City of Albuquerque

November 24, 2003

**Re: Jefferson Commons II – Lot 1, Grading and Drainage Plan
Engineer's Stamp dated 11-14-03 (F17/D84)**

GRADING AND DRAINAGE PLAN

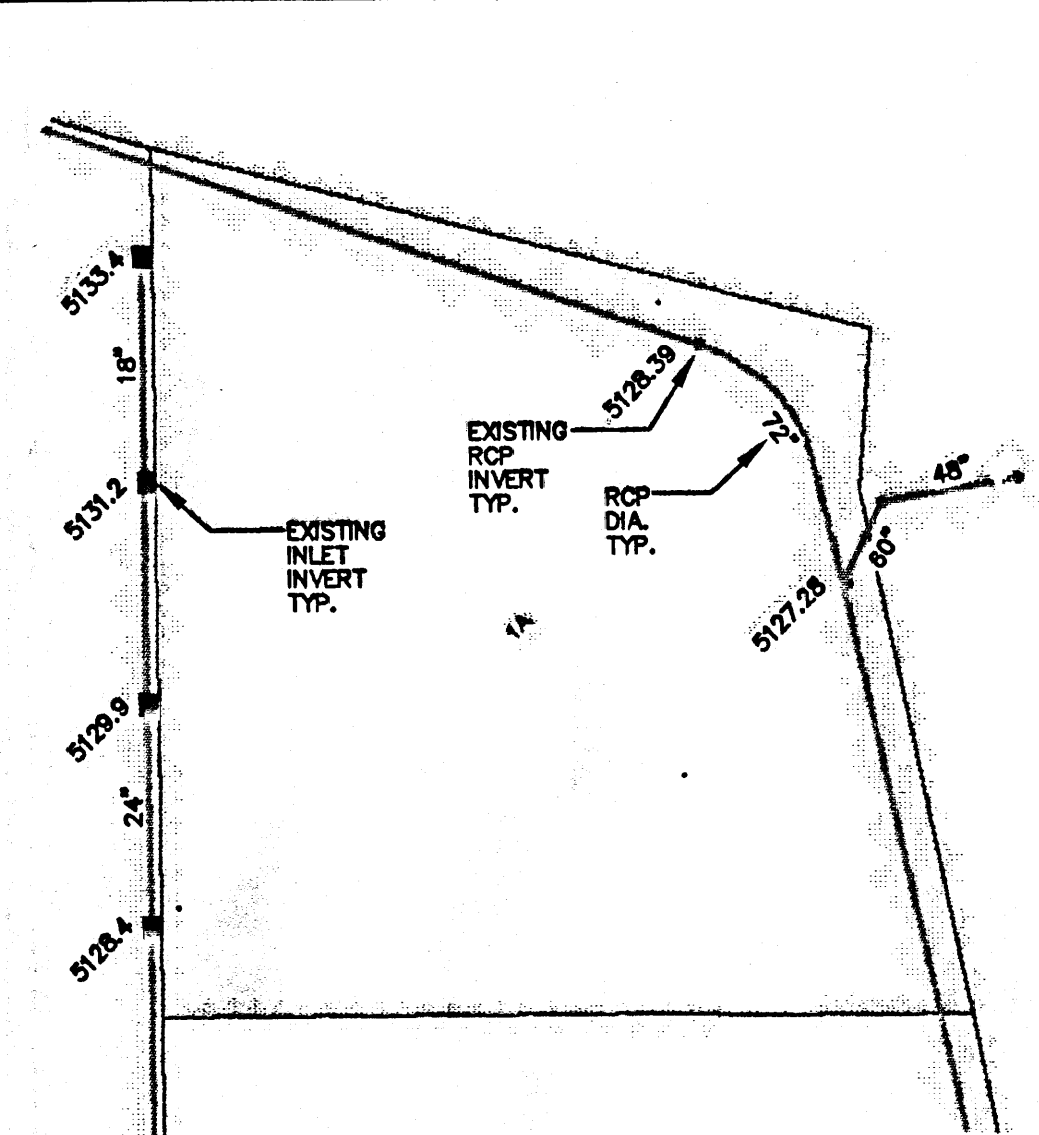
1. An existing storm drain and easement, located along Jefferson and the I-25 Frontage Road, were shown on the previous submittal, but are no longer shown.
- ✓ 2. Jefferson Street and the I-25 Frontage Road are not labeled.
3. The proposed storm drain and inlets on the south side of the site are not labeled.
4. The proposed tie in to the existing 24" storm drain does not provide any detail regarding its installation.

- Since you are building a wall in the NMSHTD R/W, written concurrence of this plan is required.
- Please show SD easement on the grading plan.

1. A work order is planned for this area (see work order number 689781) to install a deceleration lane along Jefferson Street. The above referenced plan must show these future conditions.
